Highways Response Note (2022/0619)

8 September 2022
Version 1.1
Issue

Fore Consulting Limited (Fore) has been commissioned by Rouse Homes Limited (Rouse) to provide transport advice on land at Woolley Colliery Road, Darton. An outline planning application (ref: 2022/0619), seeking detailed consent for access, has been submitted to Barnsley Council (BMBC) for 115 residential dwellings. The land is allocated for residential use as site HS1 in Barnsley Local Plan.

**SHEET 2
ROAD ACCESS NORTH
SCALE 1:250**

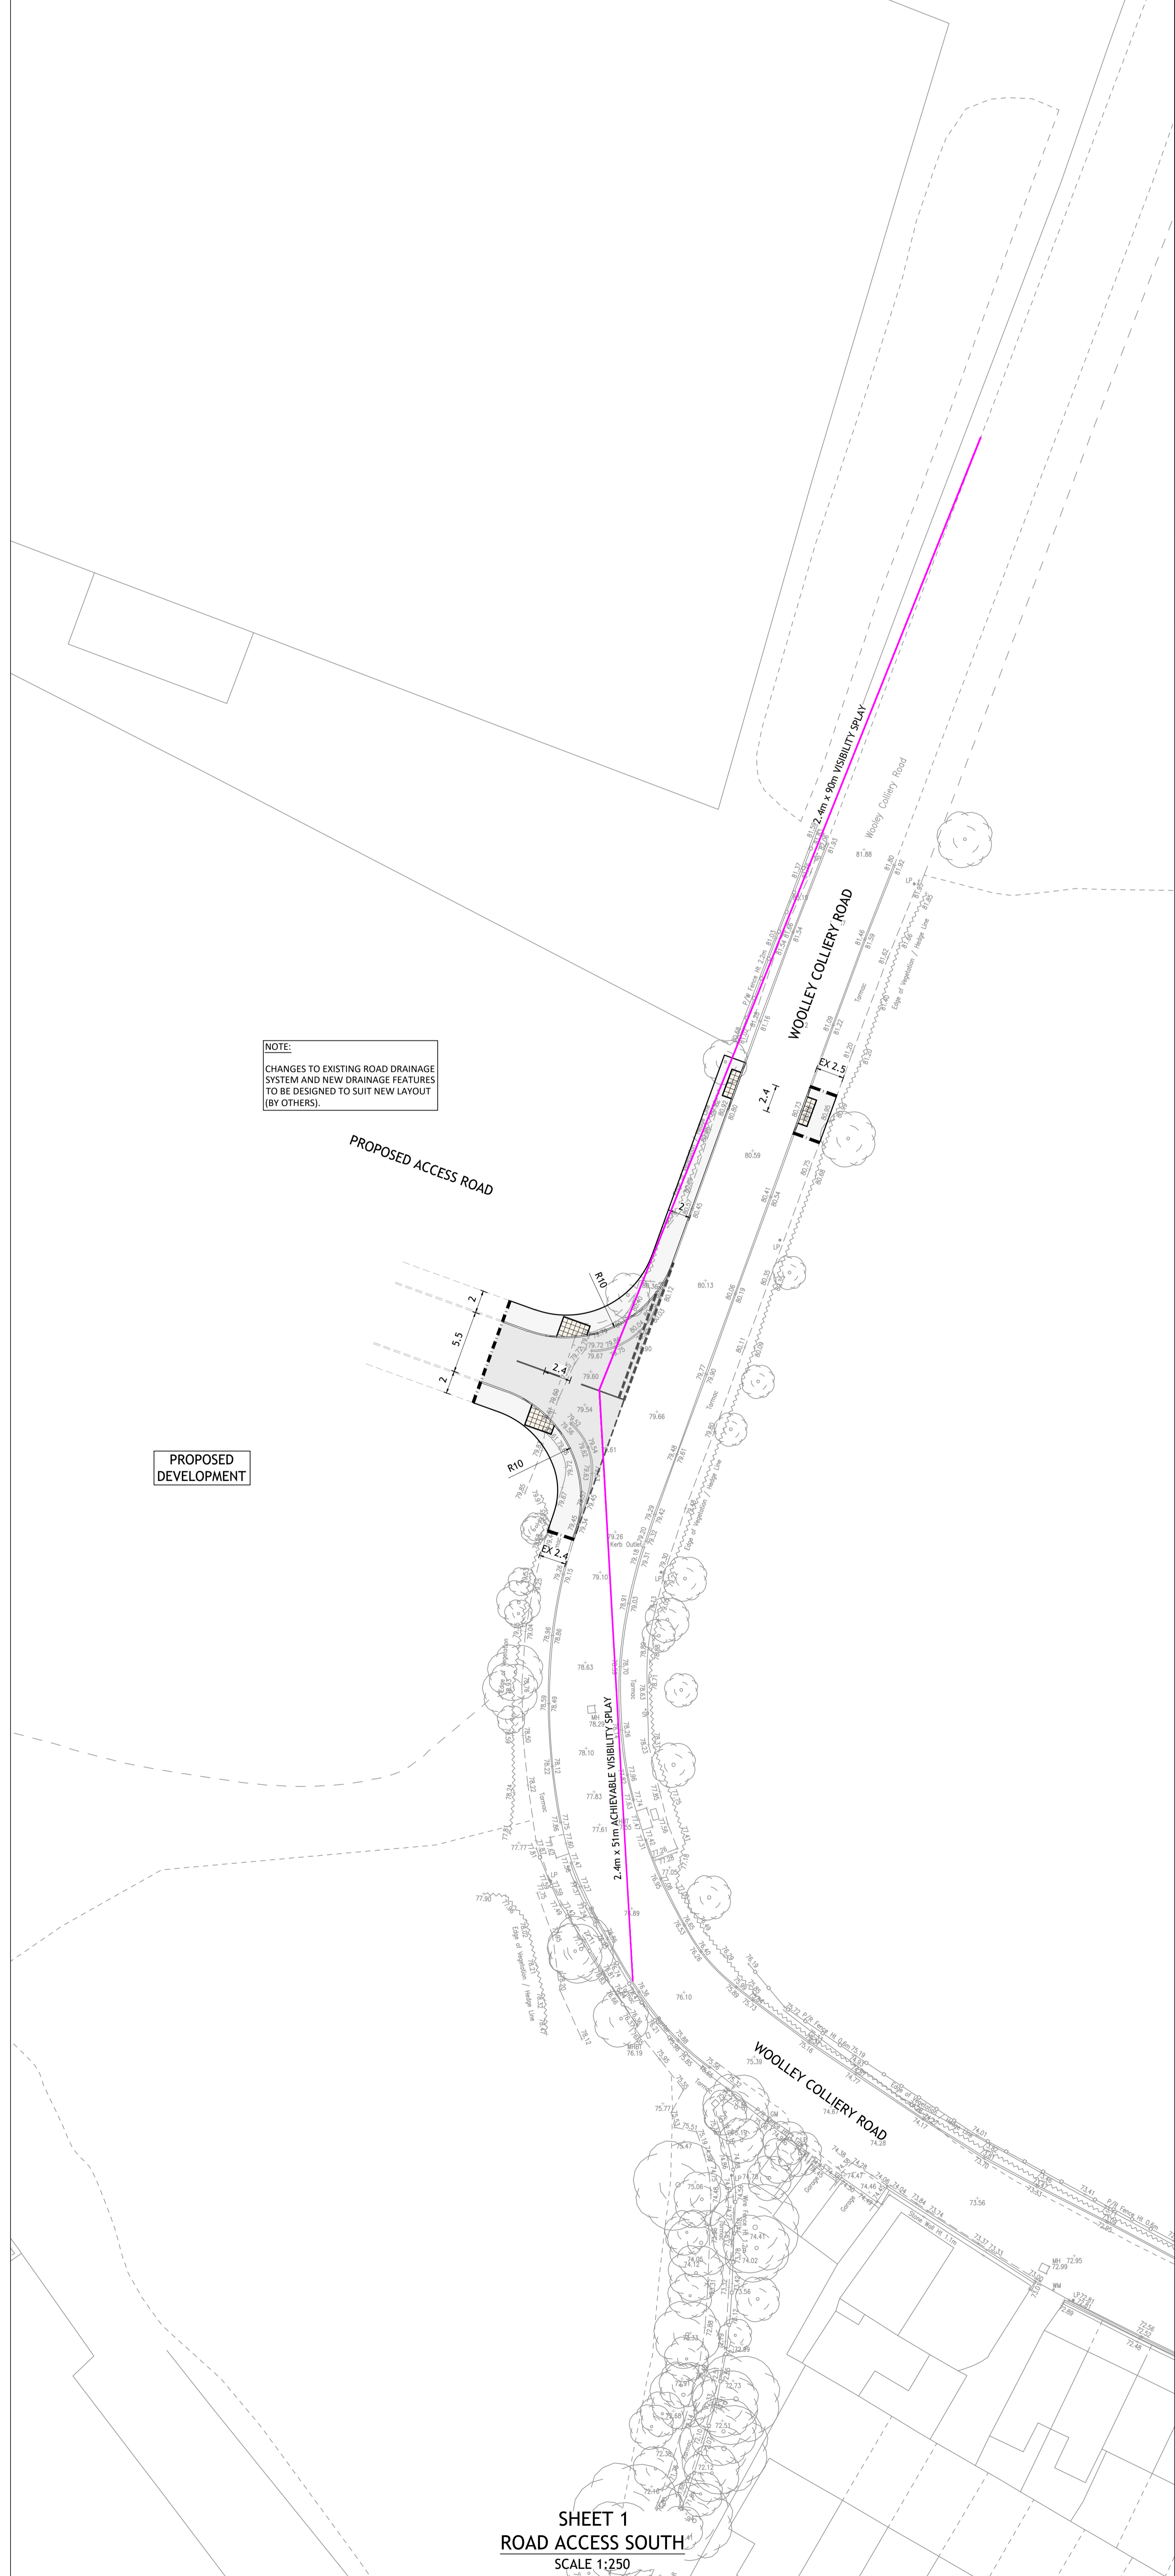
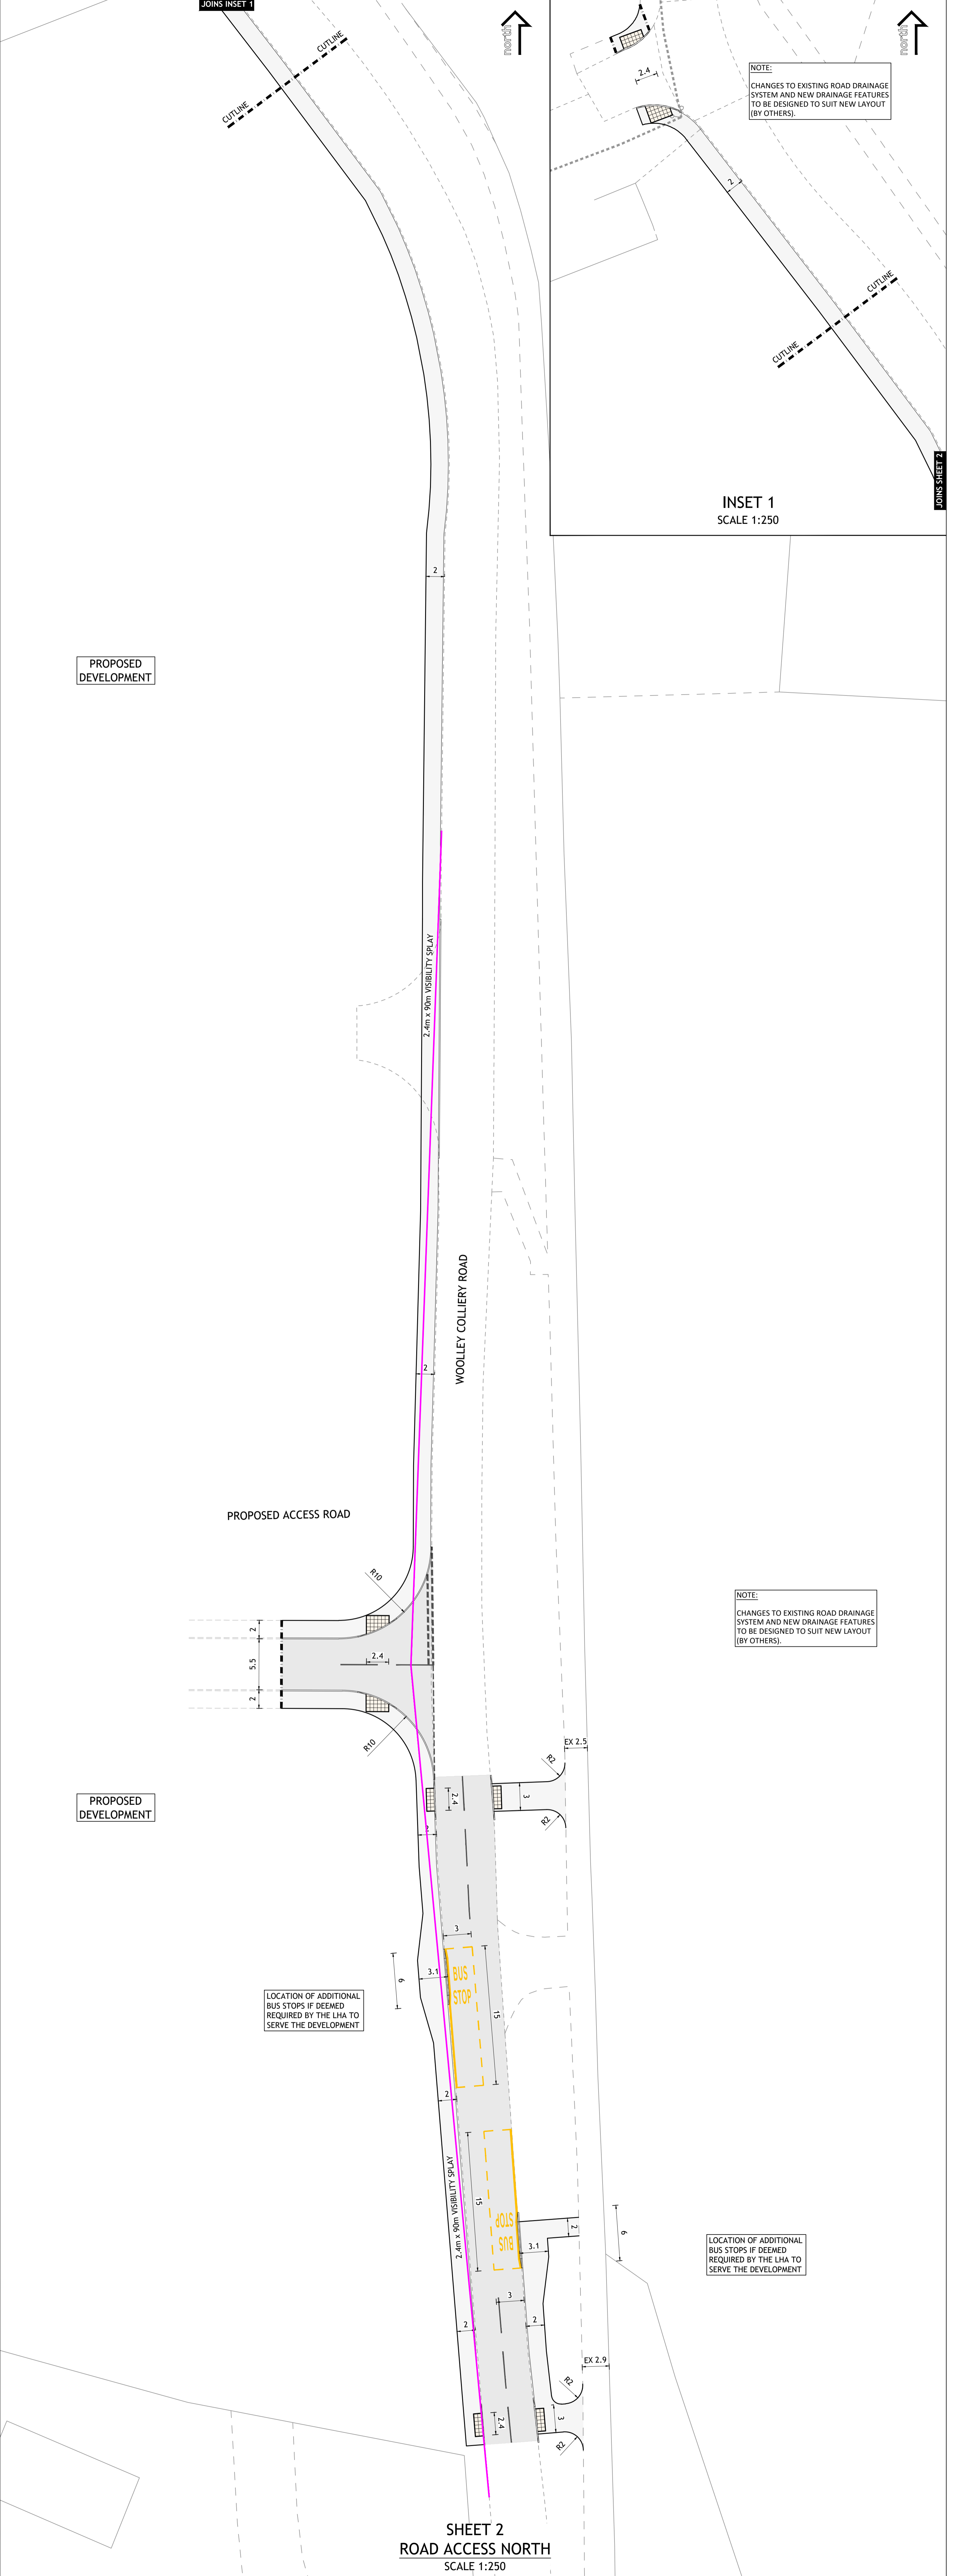
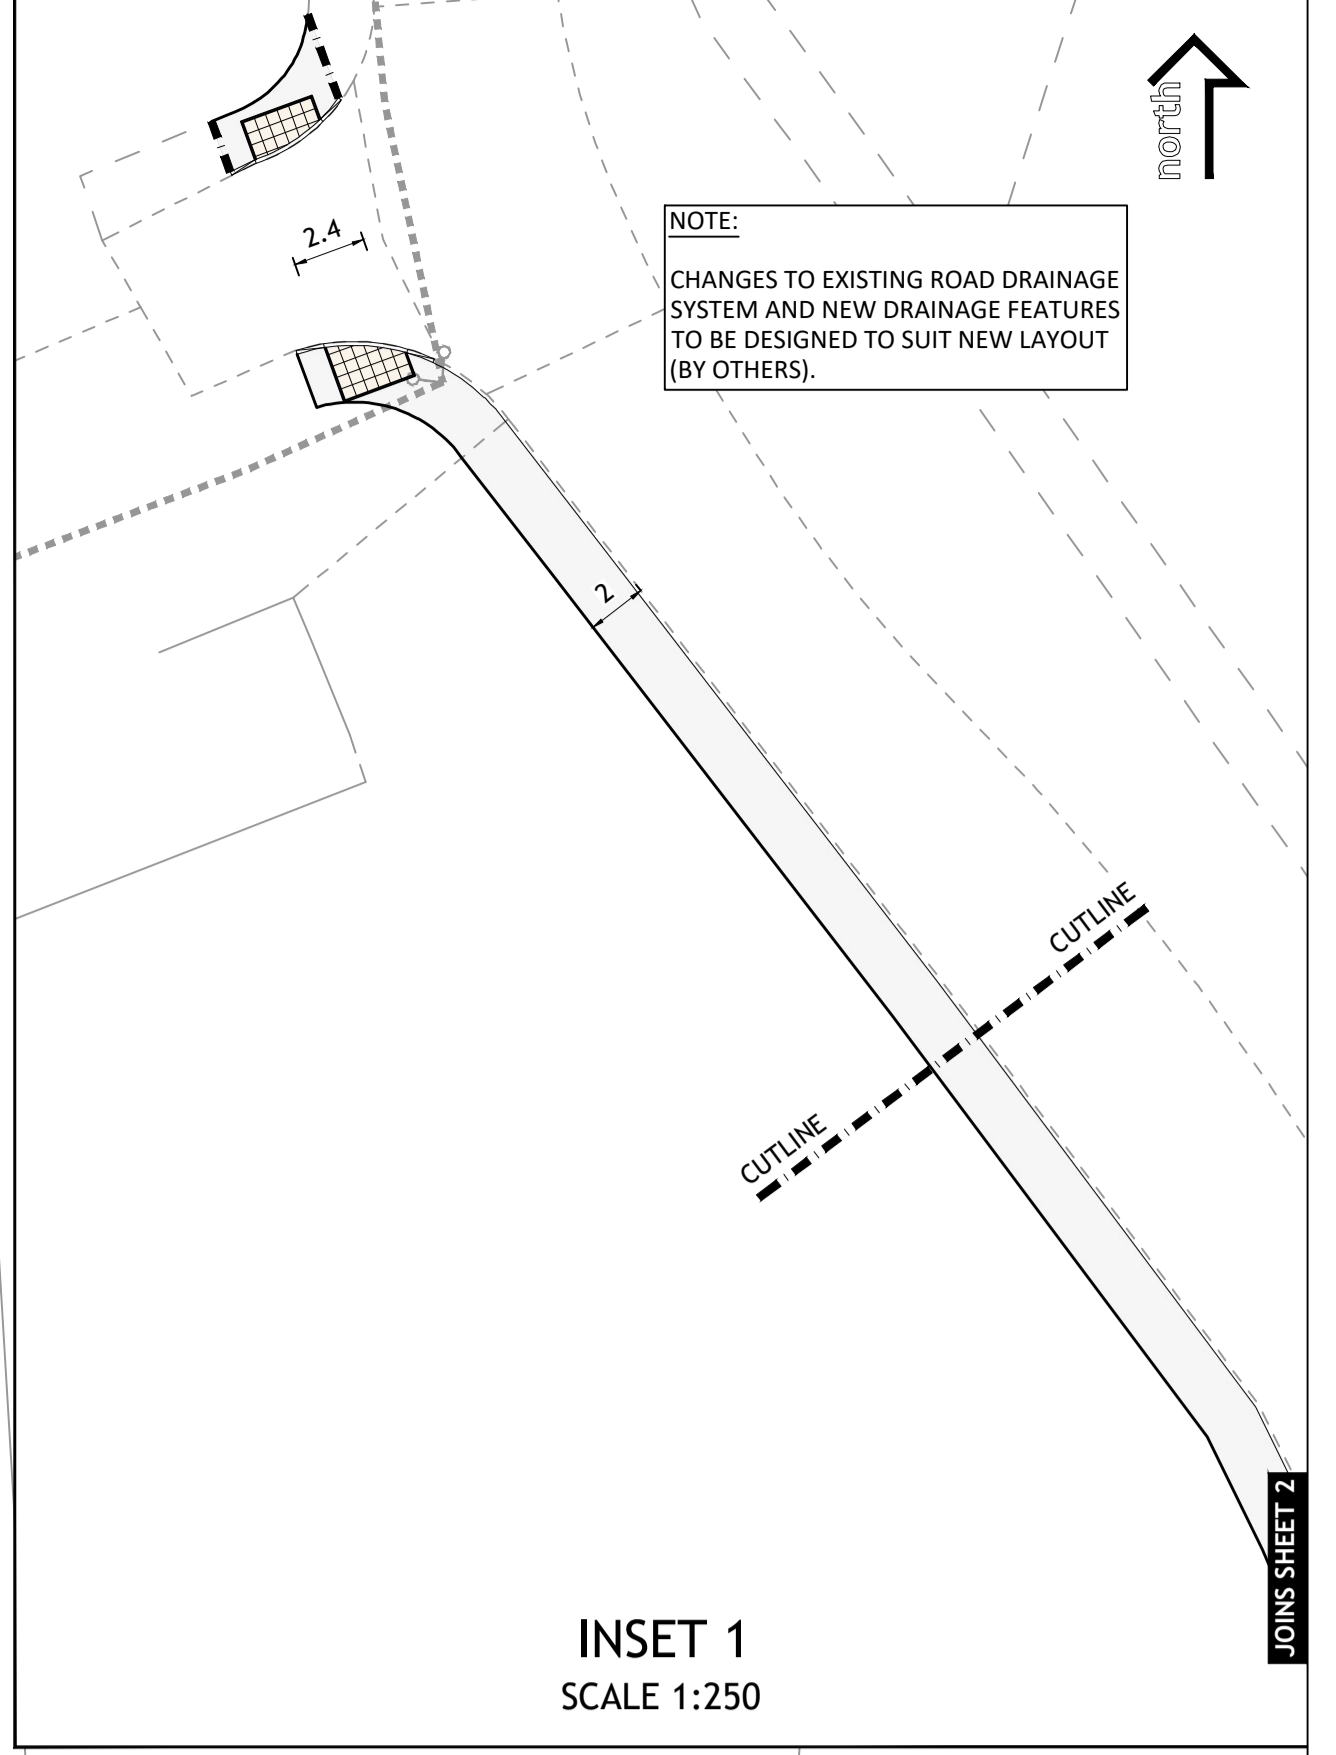
“With regard to the northern extent of the proposed off-site highway improvement works (a small portion of the proposed footway provision along with a pedestrian crossing point with tactile paving), I note that these works are both outside of the adopted highway and also outside the boundary of this Local Authority.”

Noted. Our understanding from the applicant is that the proposed improvements are either on land within the applicant’s control or within existing adopted highway. In this scenario, the proposed improvements are within Wakefield District boundary and works beyond the BMBC boundary can be agreed with the adjacent highway authority accordingly.

Alternatively, the applicant is willing to amend the proposed works accordingly to remove anything beyond the BMBC boundary.
